INSTALLATION OF KITCHEN EXTRACTION SYSTEM AT
THE KINGS ARMS, THE GREEN, SHOULDHAM, PE33 0BY

PLANNING PERMISSION REF. NO. 22/00491/F

PLANNING APPLICATION FOR VARIATION OF PLANNING CONDITION 2

SCALES:- 1:100  
DATE:- AUG. 2022  
DRG NO:- 1715.1

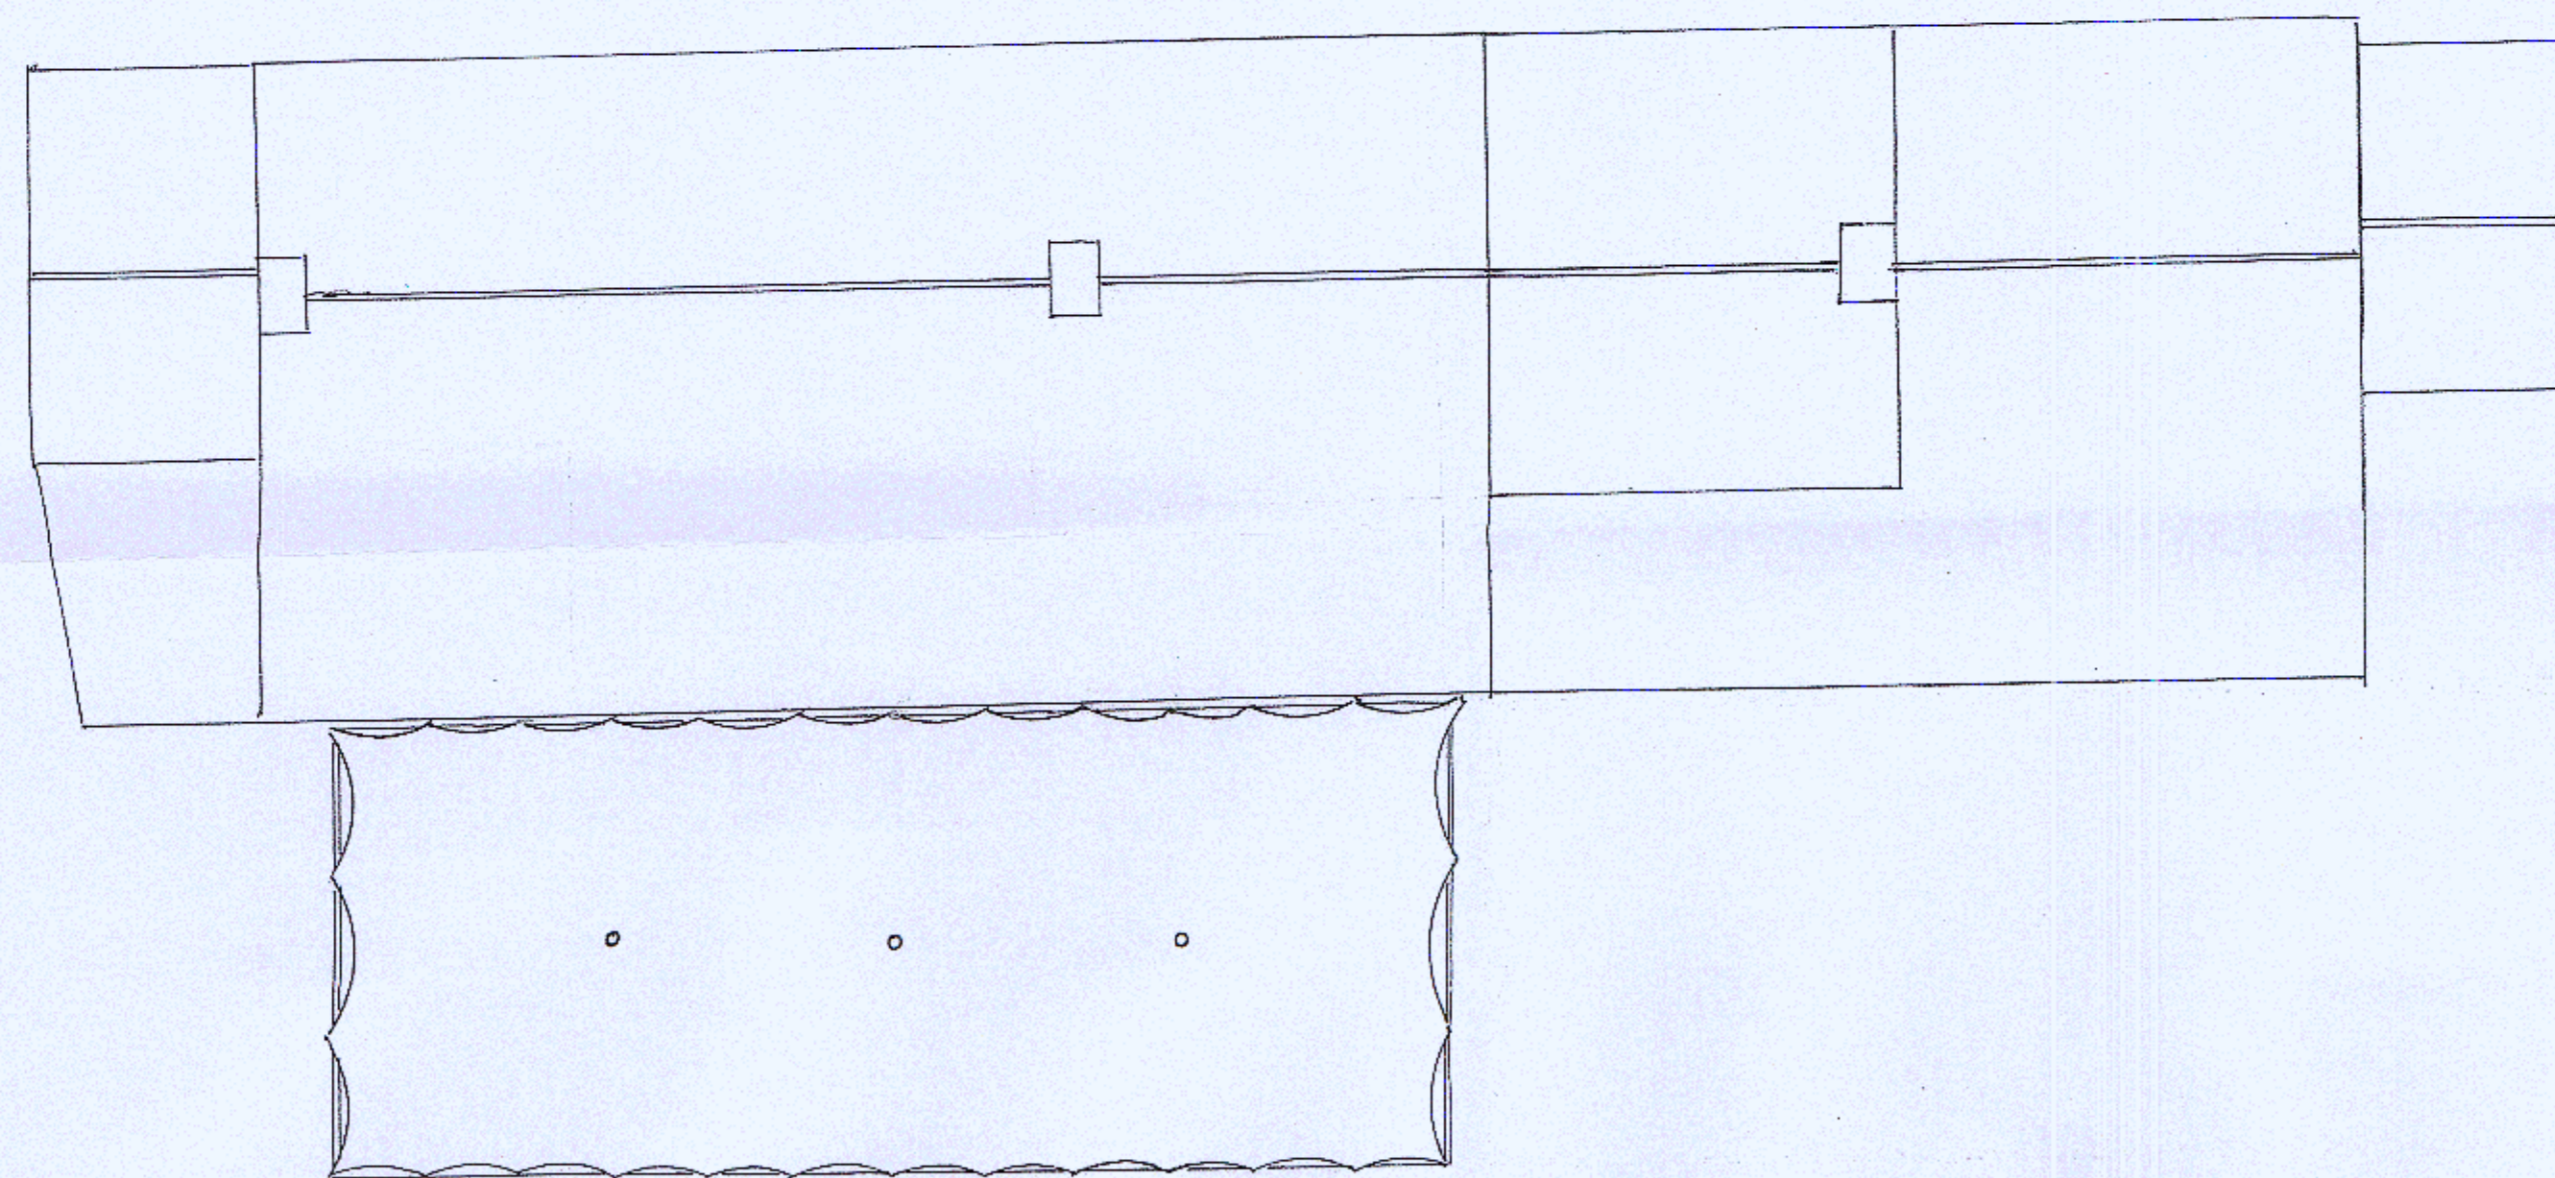
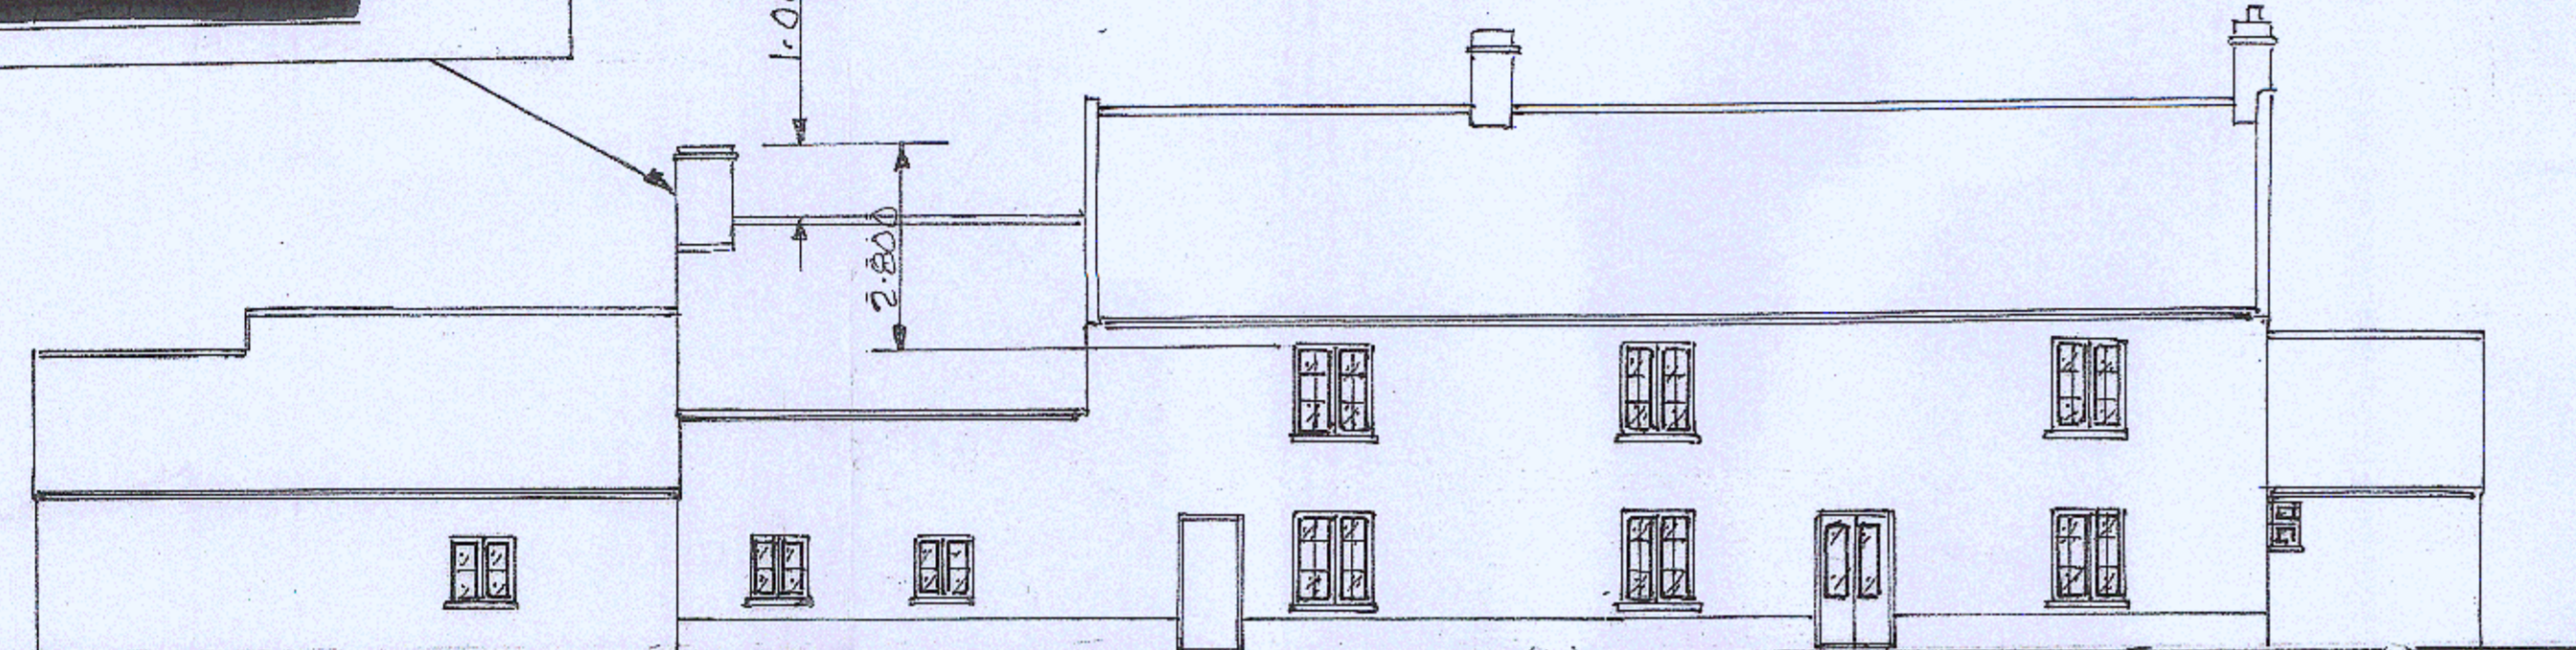
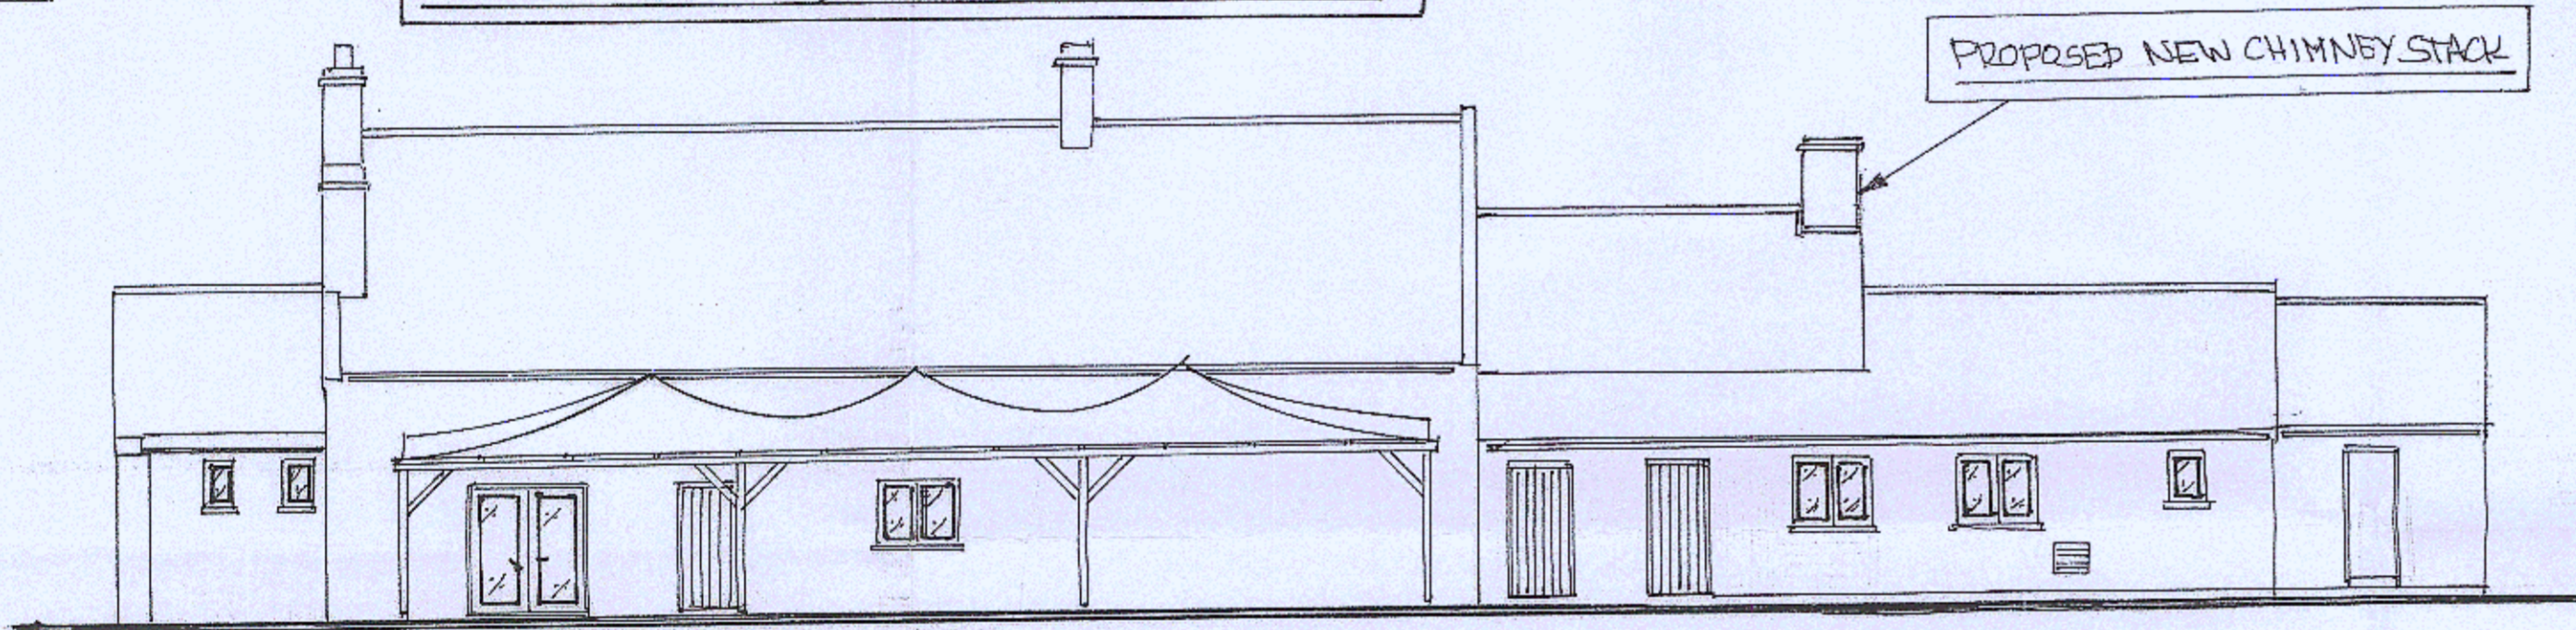
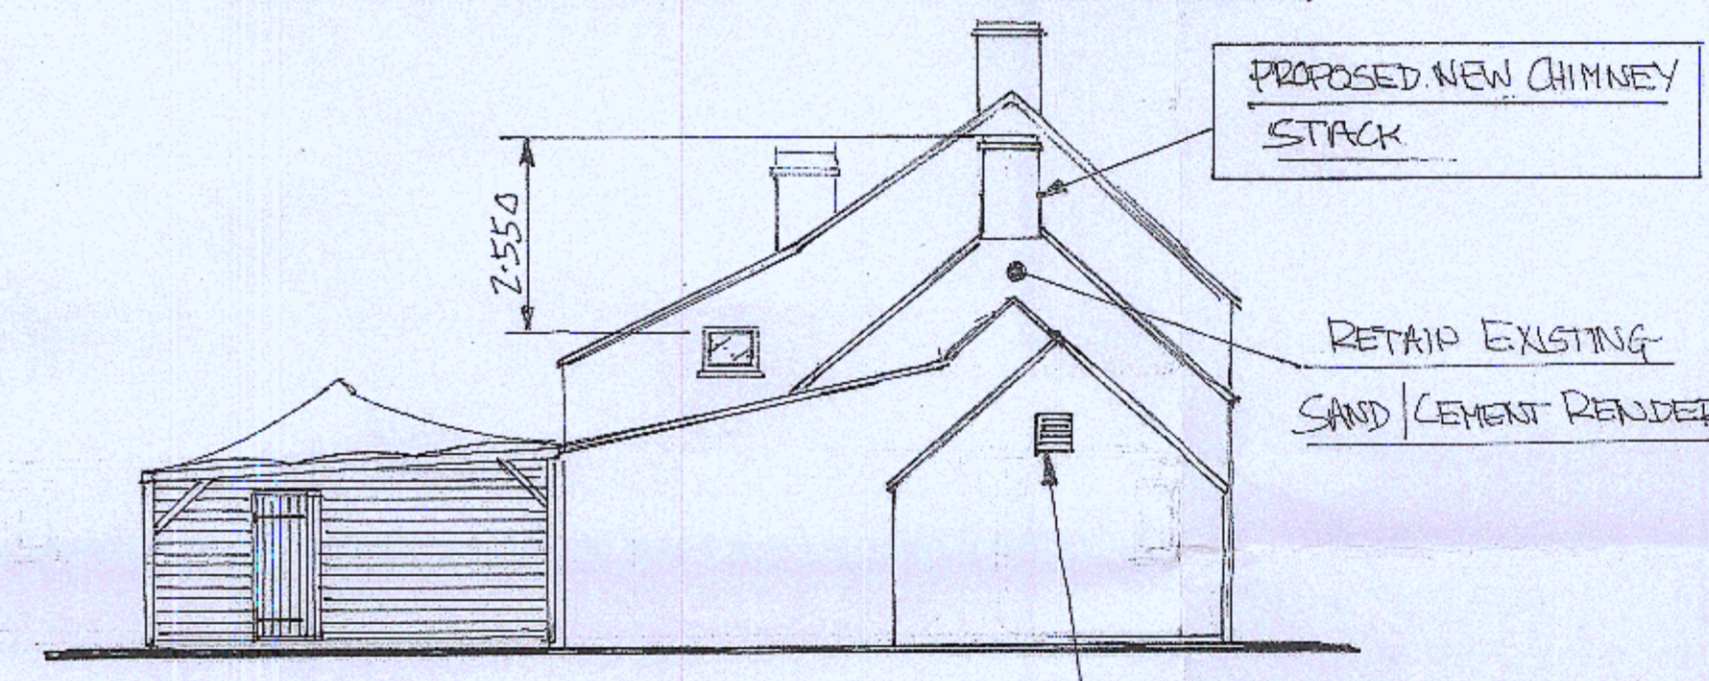
The proposed kitchen extraction system will terminate in a newly constructed chimney. The current planning consent refers to drawing number 1715.1, where the chimney stack would be constructed with a clay chimney pot.

Our designers, C.K.Direct, have advised us that the kitchen extraction system will need an internal dia. of the ductwork of 450mm., and this internal dia. should be maintained throughout the entire length of the extraction system.

Chimney pots of 450mm internal dia. are simply not made. As a result, it is now proposed that the chimney will not include a chimney pot, but the brickwork forming the chimney stack will extend to a height of 1.000m. above the ridge line. Copies of drawing number 1715.2 - revised 20/12/2022 are enclosed with this application.

Revision to drawing number 1715.1 - chimney
